A57 Link Roads

**9.13 Statement of Common Ground with
Peak District National Park Authority**

9.13 STATEMENT OF COMMON GROUND WITH PEAK DISTRICT NATIONAL PARK AUTHORITY

Table 3.2: Table of Issues/Matters - Final Version dated 10th May 2022.

**6.4 Environmental Statement
Figure 11.4 - Operational Noise Study Area**

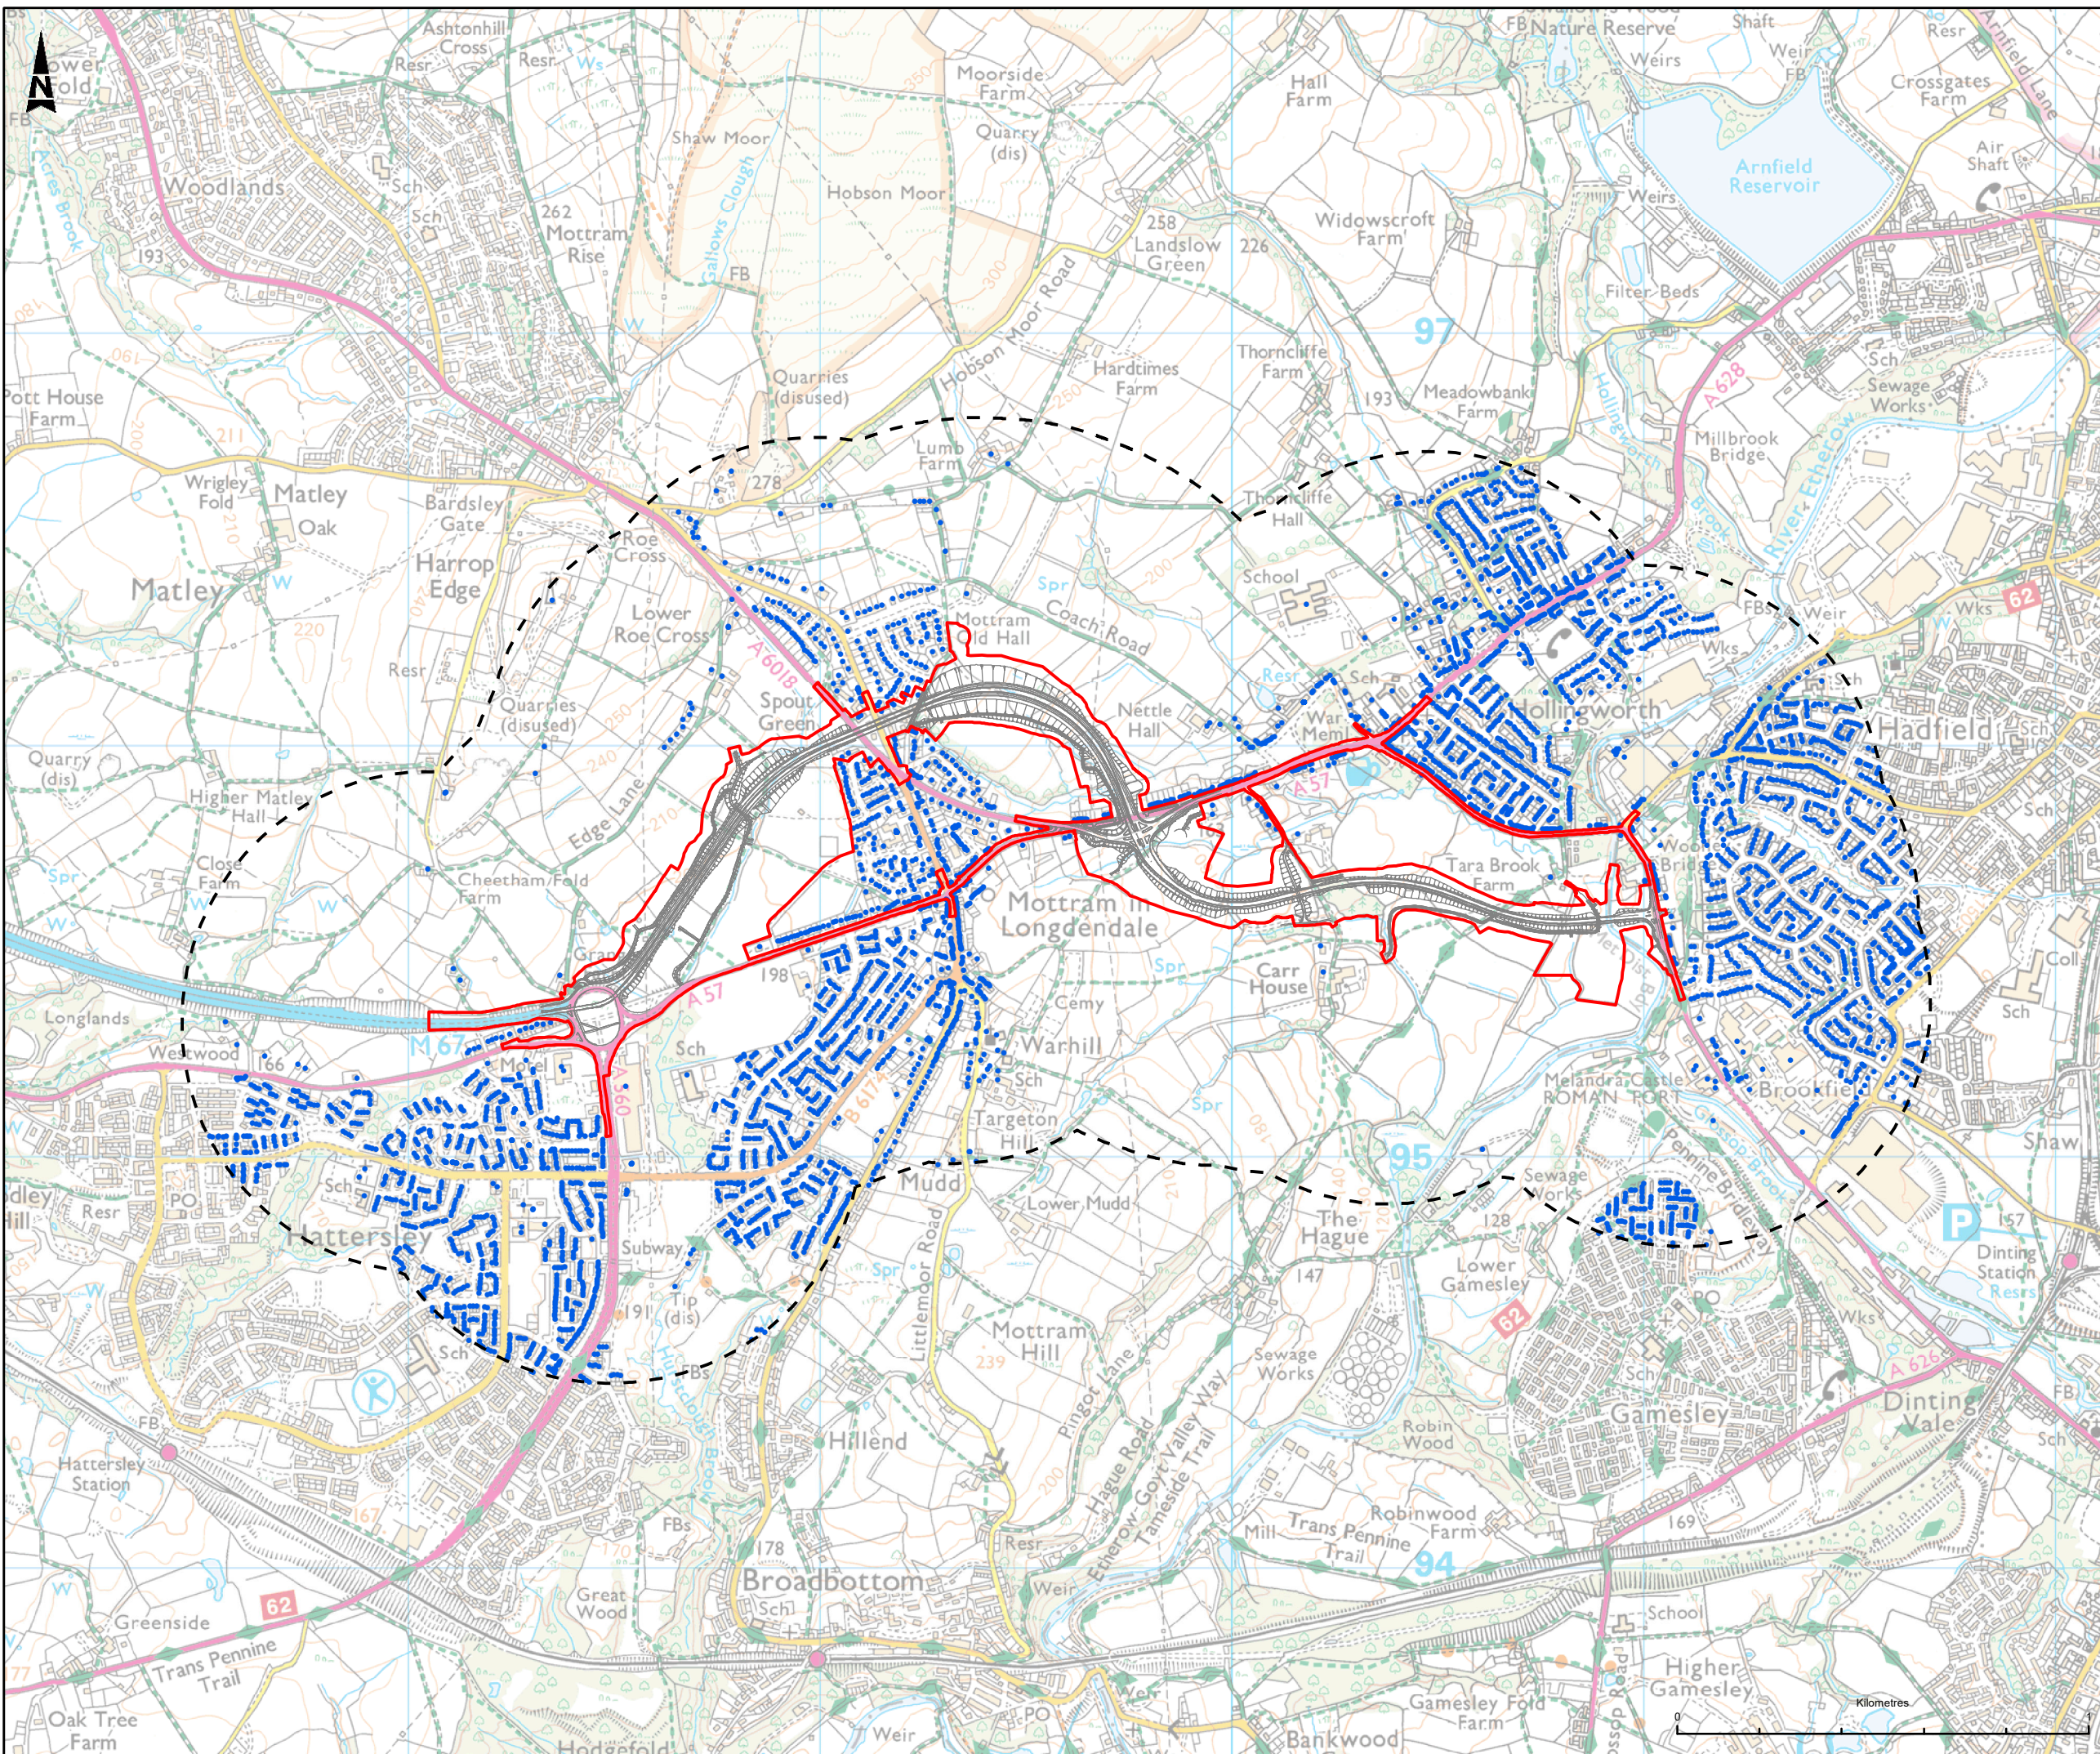
| SoCG Ref. Number | Relevant examination document | Relevant Issue | PDNPA comment | National Highways response | Status |
|------------------|--|----------------------------|--|---|------------|
| 2.3.4 | <p>ES Chapter 7: Landscape and visual effects (APP-063)</p> <p>Chapter 11: Noise and vibration (APP-067)</p> | Effects on quiet enjoyment | <p>From the PDNPA Relevant Representation (RR-0677-10):</p> <p>We have concerns regarding the effects of the scheme on the following:</p> <p>b) Effects on quiet enjoyment – existing traffic levels on the A628 Woodhead and A57 Snake Passes have a negative impact on the tranquillity of the surrounding open countryside, with traffic noise being a major feature. Increased levels of traffic along these routes will further reduce tranquillity, especially for those using the trails or footpaths that parallel or cross these busy roads (e.g. Pennine Way, Pennine Bridleway, Trans Pennine Trail (TPT)).</p> | <p>National Highways response to PDNPA Relevant Representation (RR-0677-10):</p> <p>Chapter 11: Noise and vibration of the Environmental Statement (APP-067) includes an assessment of road traffic noise levels from the A628 and A57 with the Scheme and impacts to users of footpaths within the PDNP (paragraphs 11.9.86 to 11.9.89).</p> <p>The modelled operation phase traffic flows on the A628 at Tintwistle and Woodhead through the PDNP were not predicted to cause a perceptible change in noise level in the short or long-term. The A628 is adjacent to the Trans-Pennine Trail and crosses the Pennine Way; impacts on these footpaths would be negligible from changes in traffic on A628.</p> <p>Traffic flows on A57 Snake Pass and A57 Snake Road, which cross the Pennine Way, would increase to give a perceptible noise increase in the short-term, however by the future year the increase would have a negligible impact according to DMRB LA 111 criteria. Therefore noise levels in these areas near the A57 would perceptibly increase in the short-term, and the impact would be limited to within approximately 10m of the road and not the entirety of the PDNP.</p> | Not agreed |

| SoCG Ref. Number | Relevant examination document | Relevant Issue | PDNPA comment | National Highways response | Status |
|------------------|-------------------------------|----------------|--|---|--------|
| | | | <p><u>PDNPA Comments Received 03/05/2022</u></p> <p>We do not believe that the perceptible impacts of the scheme on tranquility are limited to 10m from the carriageway. Topography plays a role in how these perceptions are formed, with valley settings projecting noise from the roadway along the valley sides. Traffic noise on roads is perceptible over much greater distances than 10m, particularly so in settings that are otherwise tranquil.</p> <p>We requested that the consultant look to undertake a ‘local’ landscape character assessment, rather than just using our published LCA – this is because of scale: our LCA/LCTs are ‘too big’ to allow for adequate assessment of the likely effects of the scheme – smaller units needed to be defined to allow for adequate consideration of likely effects. This was not undertaken by the consultant in their assessment.</p> | <p>Landscape receptors are landscape designations, Landscape Character Types, and parts of the A57, A624 and A628 within the PDNP. Indirect effects upon the PDNP resulting from increased traffic were assessed. Perceptual/experiential effects were included within the methodology. Paragraphs 7.3.39 and 7.3.40 of the ES (APP-063) consider the Special Qualities of the PDNP and tranquillity and wildness). There were no significant residual effects on the landscape character areas/types within the PDNP during operation.</p> <p>Viewpoints 19-26 inclusive represent views from the Pennine Way/Pennine Bridleway/Trans-Pennine Trail within the Peak District National Park (PDNP). These were set out in Chapter 7 Landscape and Visual Effects of the Environmental Statement (APP-063) Table 7.29 Indirect Effects. This recognises that traffic numbers will increase for the A57 and A628 (within the PDNP) and decrease for the A624 (within the PDNP) but that for all routes the magnitude of change of increased/decreased traffic, based on the existing scenario (whereby existing traffic affects the perception of wildness and tranquillity (the PDNP’s Special Qualities)), was not high enough to result in significant effect greater than slight adverse for visual receptors on these routes.</p> <p><u>National Highways Response – 10/05/2022</u></p> <p>With respect to the limits to consider the perceptible impacts of the Scheme on tranquillity, the assessment was undertaken from the publicly accessible locations considered most likely to represent the landscape receptors and the experience of visual receptors.</p> | |
